From: nectonparishcouncil@gmail.com
To: [Norfolk Vanguard](#)
Cc: [REDACTED]
Subject: Submission from Necton Parish Council
Date: 13 March 2019 18:45:45
Attachments: [Necton PC 2nd Response to PINS Questions 2019.docx](#)

NECTON PARISH COUNCIL RESPONSE TO PINS SECOND QUESTIONS Deadline: March 13th 2019

Drawing file: published-documents / EN010079-001659-Figure 4.13 Onshore Project Substation and National Grid Substation Extension.pdf

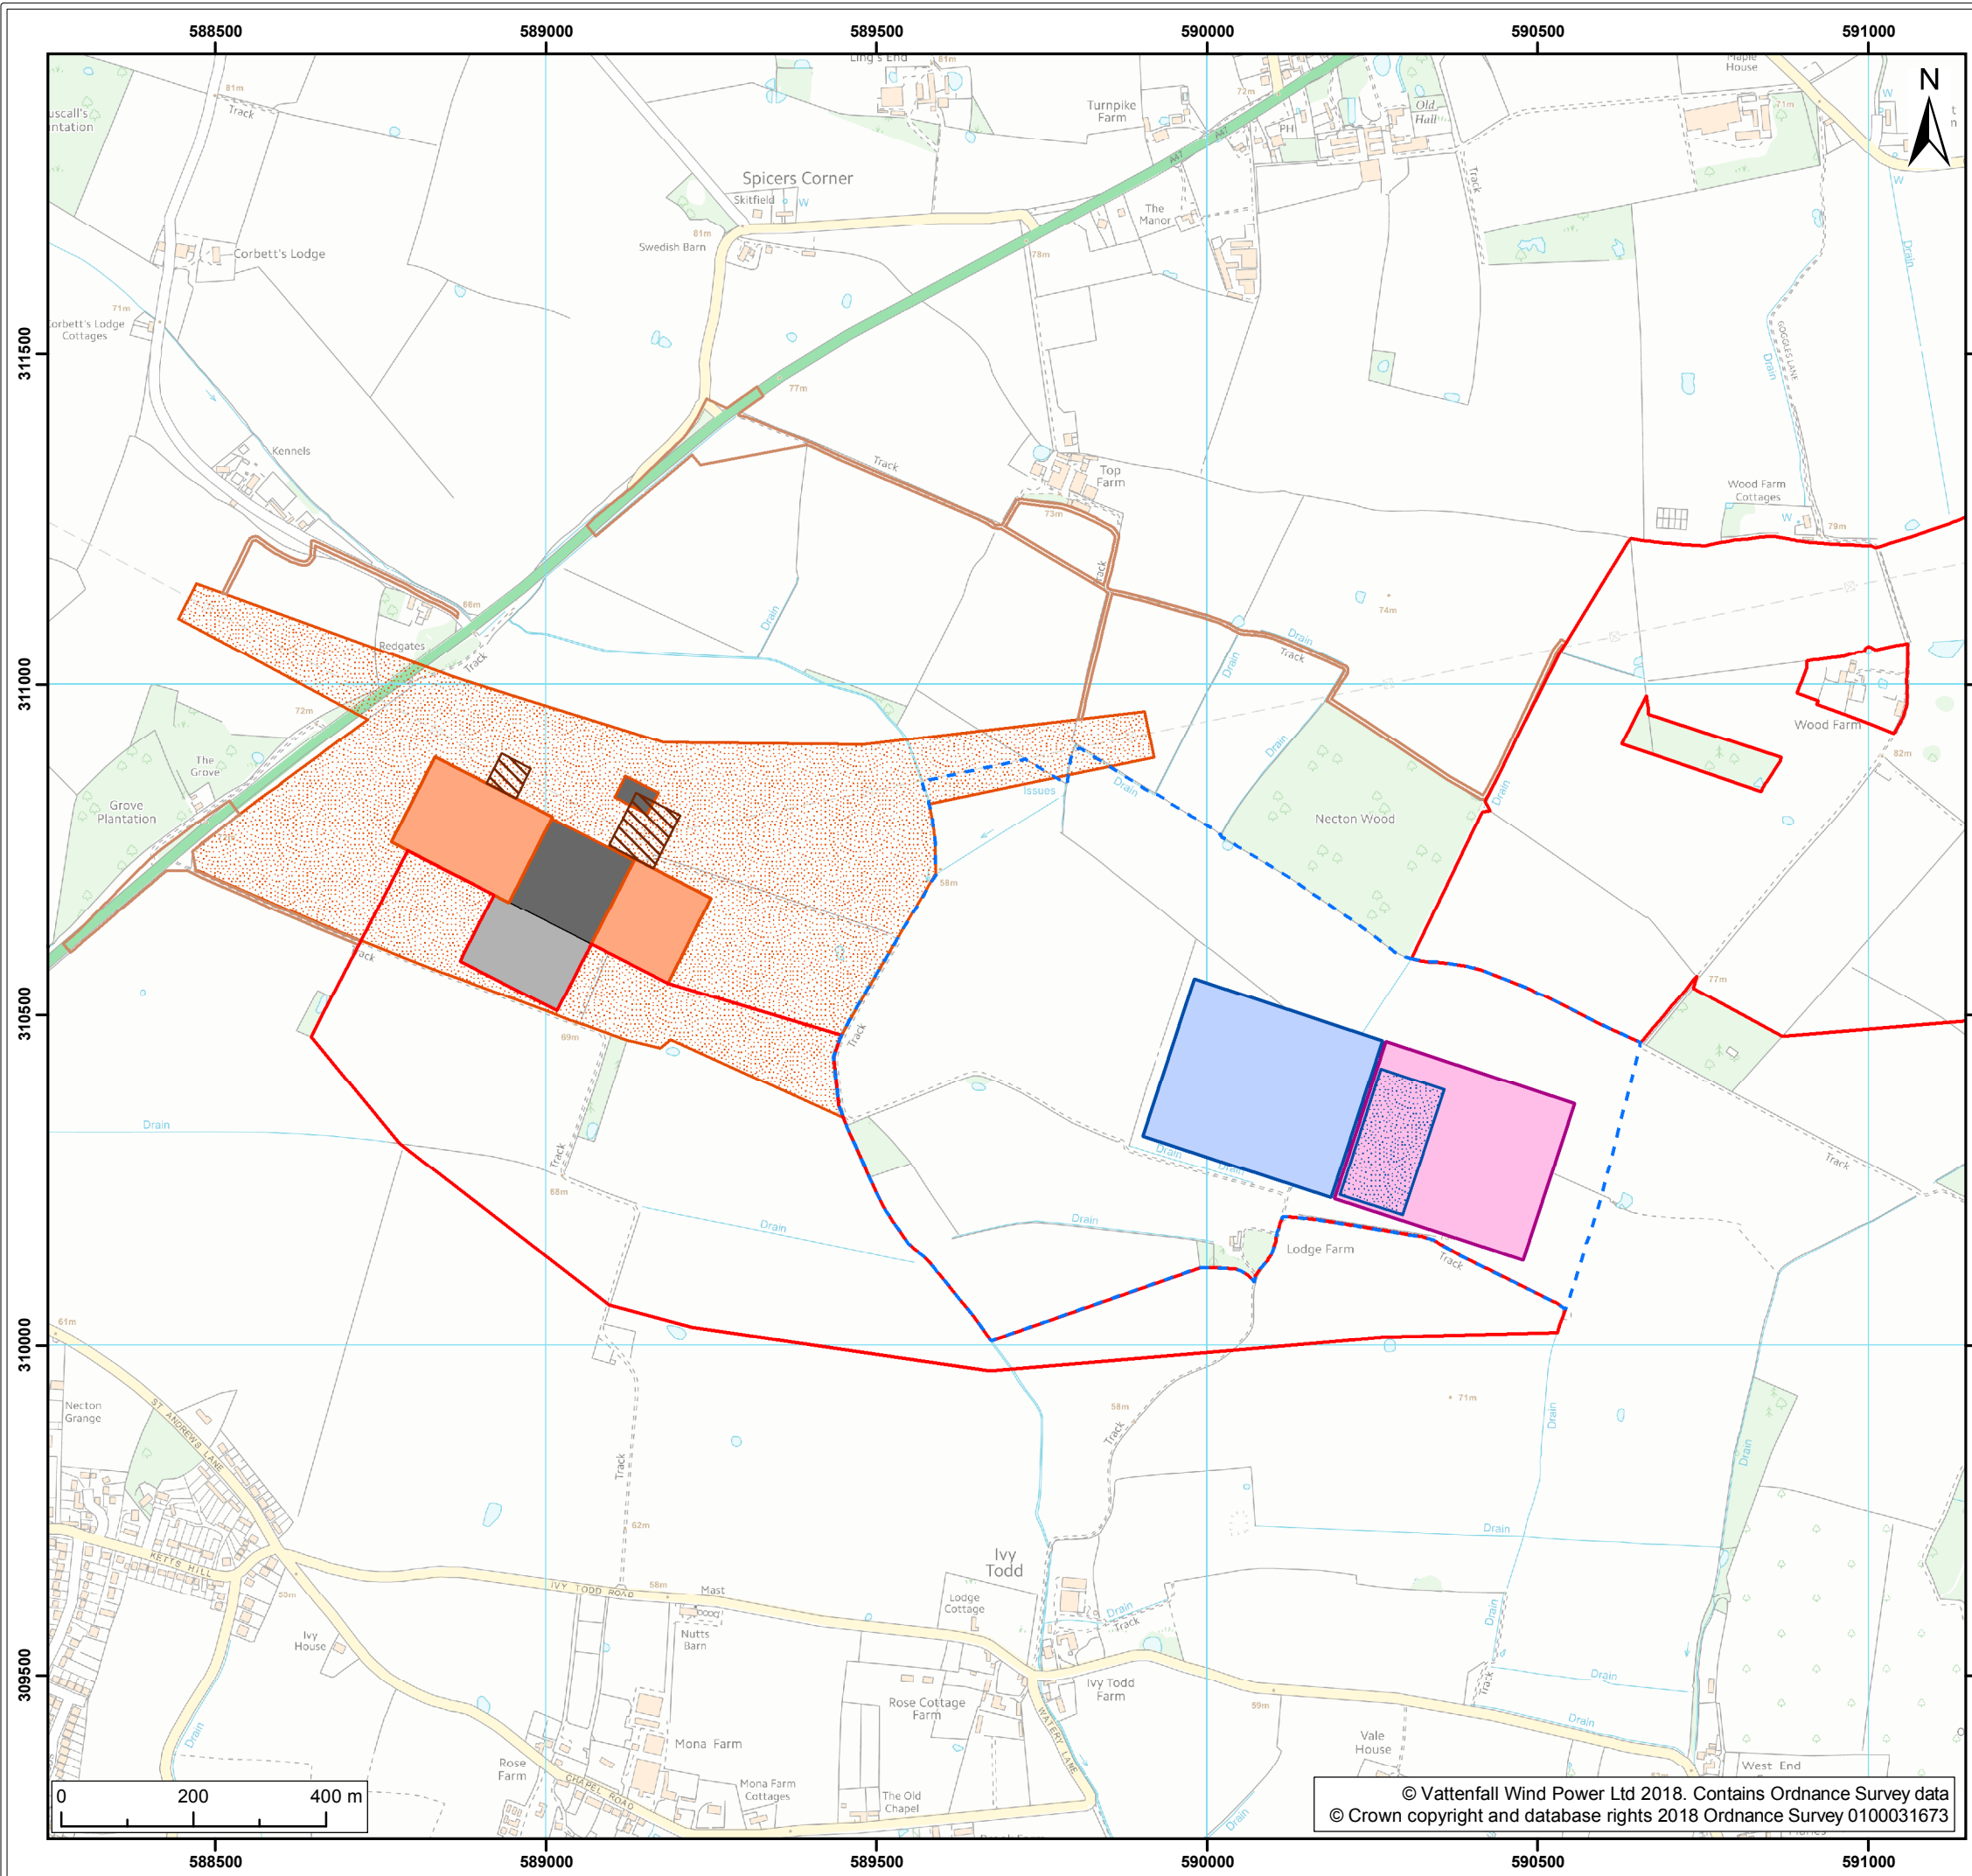
Please clarify what alternative layout within the identified site, as opposed to land outside the Order Limits, you propose if any, in relation to the siting of the substation/additional substation or its component parts.

Necton Parish Council asked Vattenfall to consider two alternative sites to the one selected. One was within the 3km 'acceptable circle' and one outside it. The site within the 3km circle is Top Farm. The road to the site chosen for access to the proposed substation site passes through Top Farm, which can potentially accommodate both the converter halls and the National Grid substations. It presents fewer issues as the site contains a significant amount of low ground and there is no contamination from the 1996 plane crash. The current plan for the National Grid substations is to replace one pylon with two pylons to allow connection to the grid network. We believe the Top Farm site would only require the replacement of one pylon with one new pylon so there would be less effect on the visual amenity of Necton both from the lower construction of the converter halls and National Grid substations. The cable route should be shorter so there should be no effect on the overall economic viability of the project.

We are not certain whether the Order Limits include the whole Top Farm site but they certainly include some of it because the proposed access road for the proposed substations runs through Top Farm. It is adjacent to the proposed cable corridor route and was already offered to Vattenfall for sale.

Necton Parish Council's preferred alternative Top Farm site is further away and in a dip so the effects from construction on Necton in general, and in particular on this tourism business, would be minimized.
